Application no: 22/01611/OUT

Location: Stratfield Farm 374 Oxford Road Kidlington OX5 1DL

Proposal: Outline planning application for up to 118 no dwellings (all matters reserved except for access) with vehicular access from Oxford Road

Objection, in relation to the following issues:

Relevant output from the DEFRA 3.0 Metric Calculation Tool

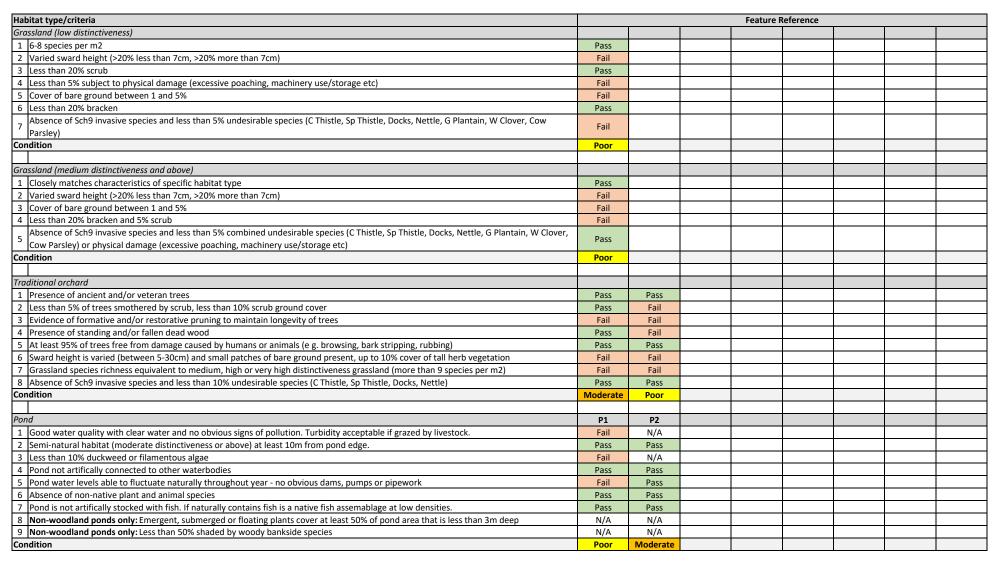
A Biodiversity Net Gain metric spreadsheet has been provided at Appendix 5176/5 of the applicant’s Ecological appraisal to illustrate the potential net gain resulting from this application. This shows a net gain of 13.31 % habitat units and 10.67% hedgerow units.

We welcome the submission of the metric spreadsheets to allow consultees to assess the scoring in detail. However, we are concerned about the scoring for *“Creation of Other Neutral Grassland – Good condition”*.

The metric provides five possible condition scores for created habitat, listed here, with their scores afterwards – Poor (1); Fairly Poor (1.5); Moderate (2); Fairly Good (2.5) and Good (3) (note that the intermediate categories of fairly good and fairly poor may be used only if it is not possible to determine between two main condition categories and justification must be provided). To select the very highest of those scores, which will likely provide the most units on the metric, needs a very high level of confidence that the condition assessment criteria are met and that the starting point, the creation techniques, and the management techniques will all combine to allow the creation of such high-quality grassland. Factors such as invasive species, recreational impact and nutrient input can also be relevant. It is common for a precautionary approach to be taken, for example by using a Condition score of Moderate (2) or at the most Fairly Good (2.5). To justify a score of Good (3), or of Fairly Good (2.5), we would ask for much more detail on the above issues to be provided than is currently available, including the submission of a habitat creation and management plan, and for that detail to be consulted on.
